KITTITAS COUNTY

MEMORANDUM

SUBJECT: Palomino Fields Plat Division 3

Surveyed by LMH  
Drawn by Tm/FCS  
Checked by FCS  
Sod 1" = 300'  
Sheet 1 of 5  
Project No. 18146

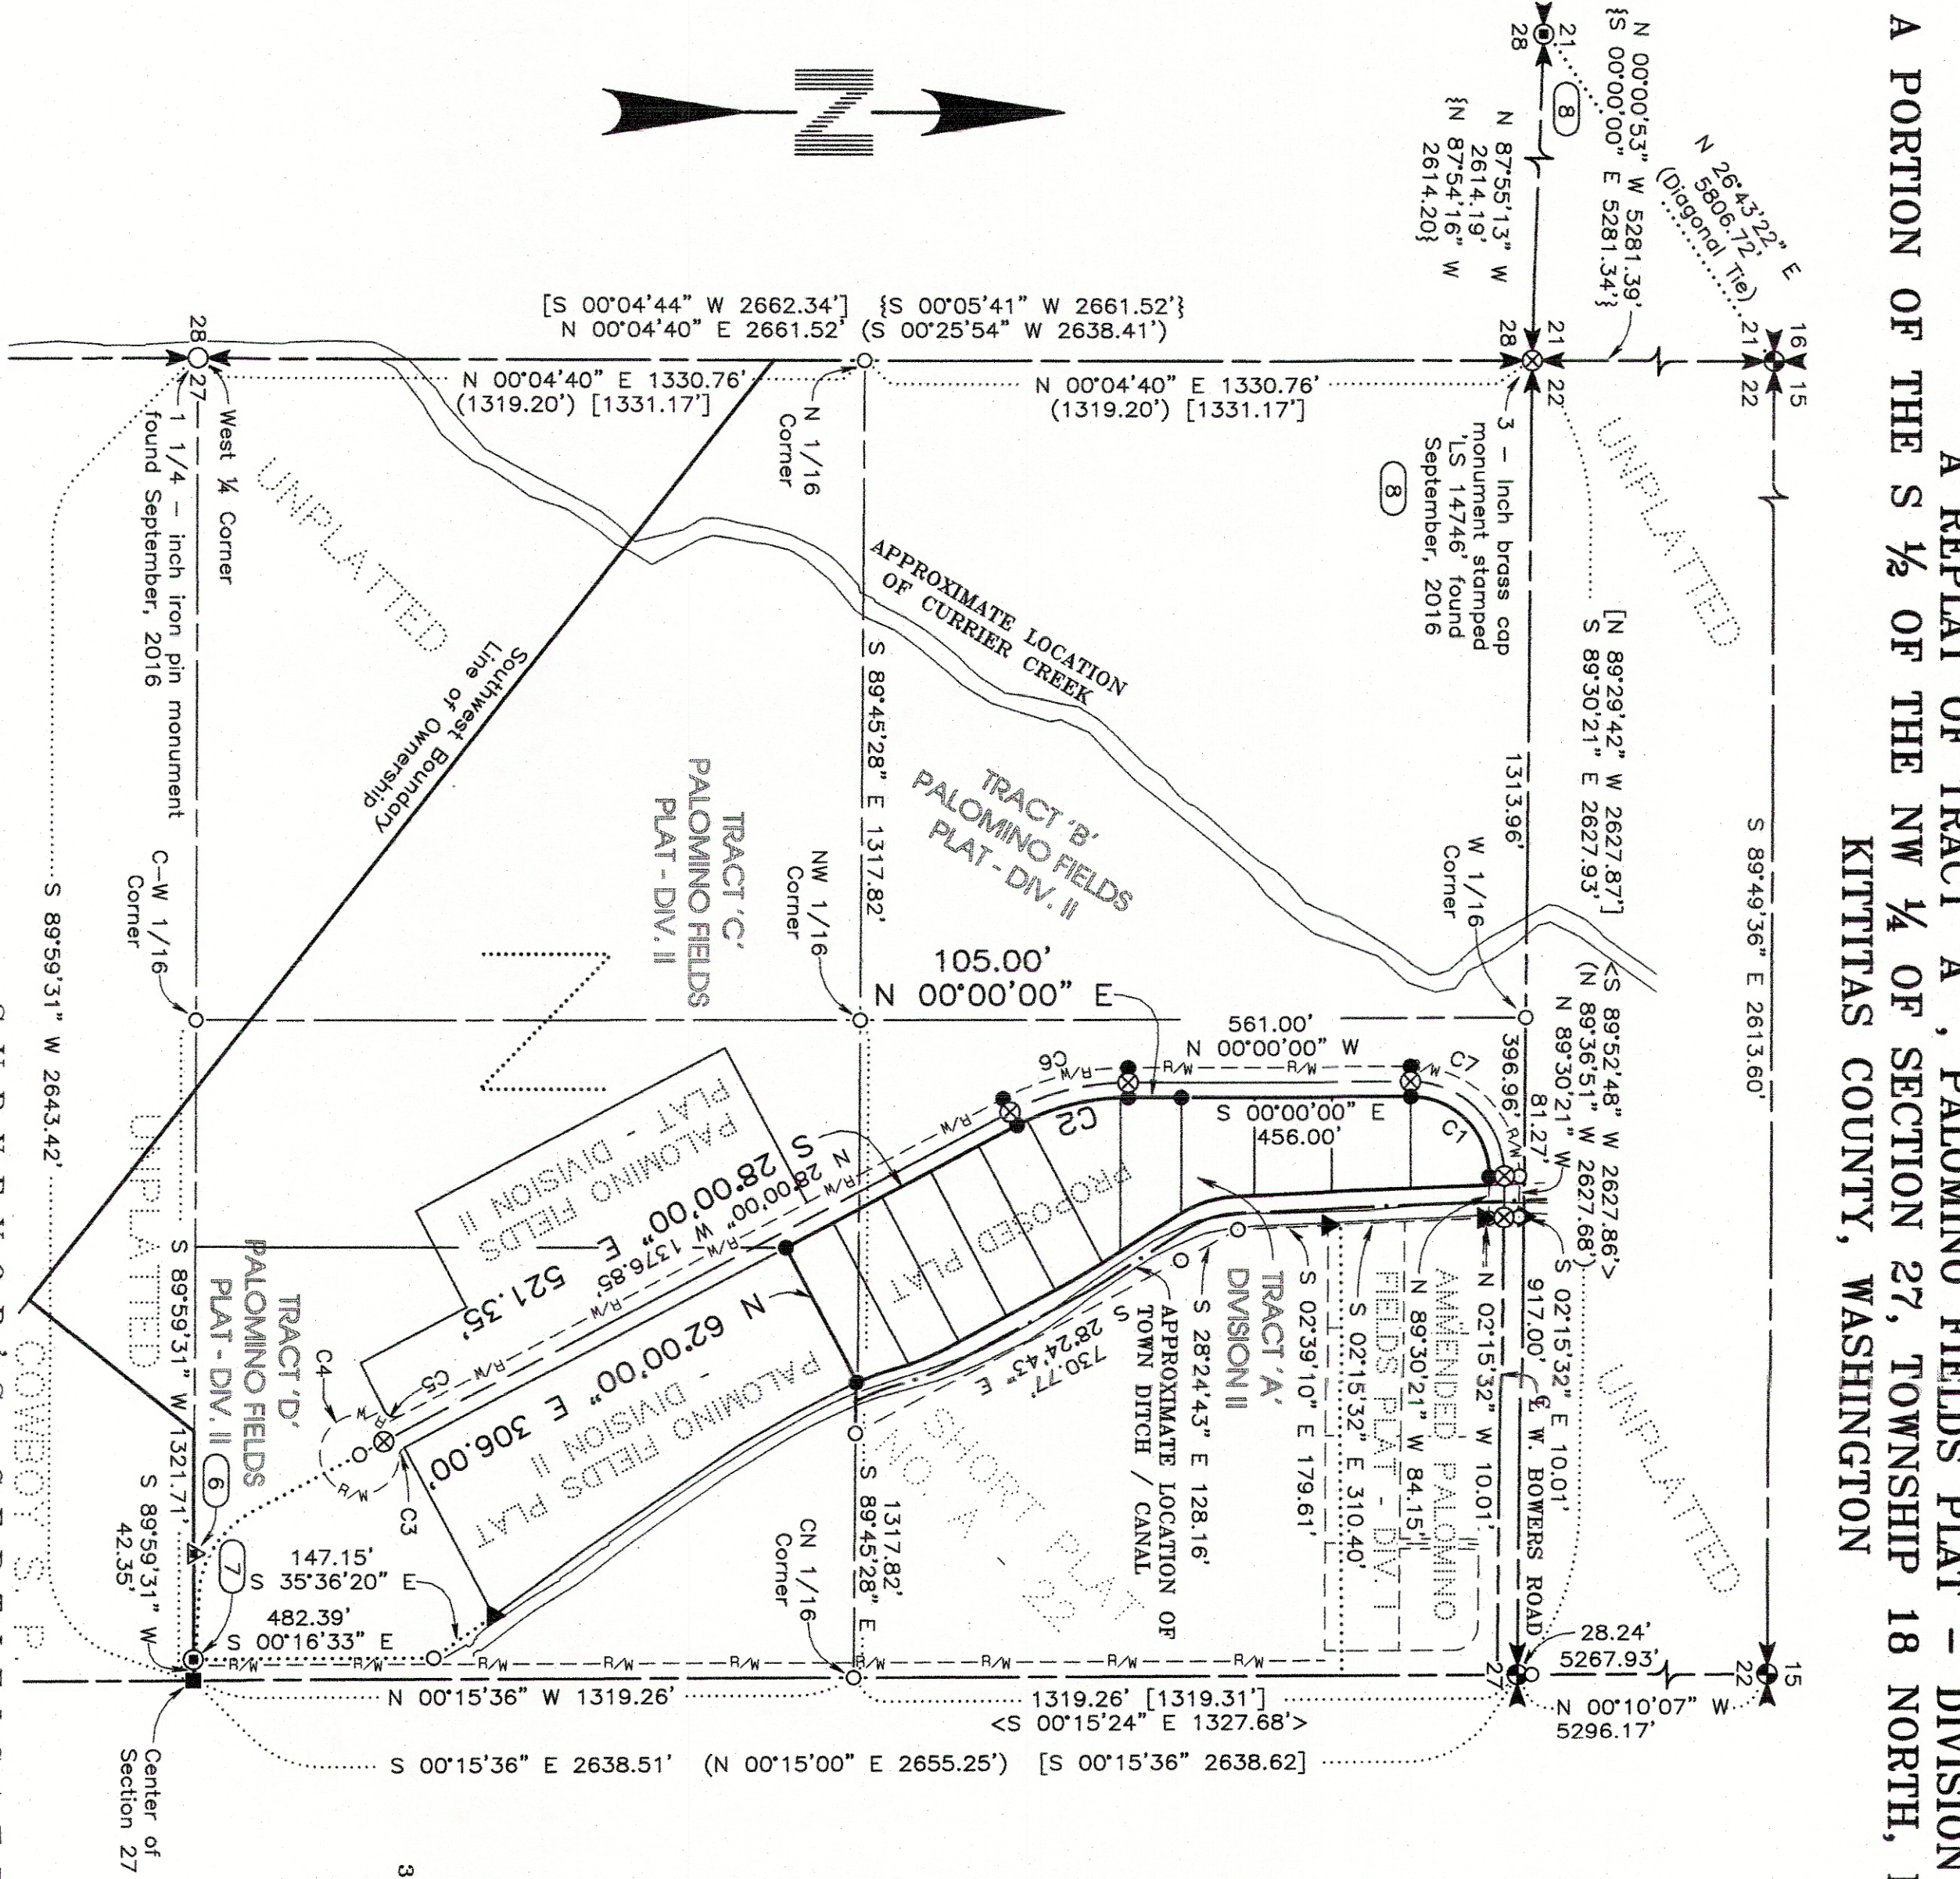
Upon preliminary review of the submitted application, there are significant discrepancies with the boundary limits as compared to that of record. It is suggested that WPE review the boundary calls against previously filed plats (Div I and II), correct and resubmit.

It is expected that that all boundaries match that of the record of the parent parcel to be divided, or the discrepancies noted. Additionally, bearings and distances should match that of the lot closure report, and a general check that labels and right of way match between pages, and previous plats of record.

The boundary of the 100-year floodplain and floodway must be shown on the face of the plat (KCC 14.08.220).
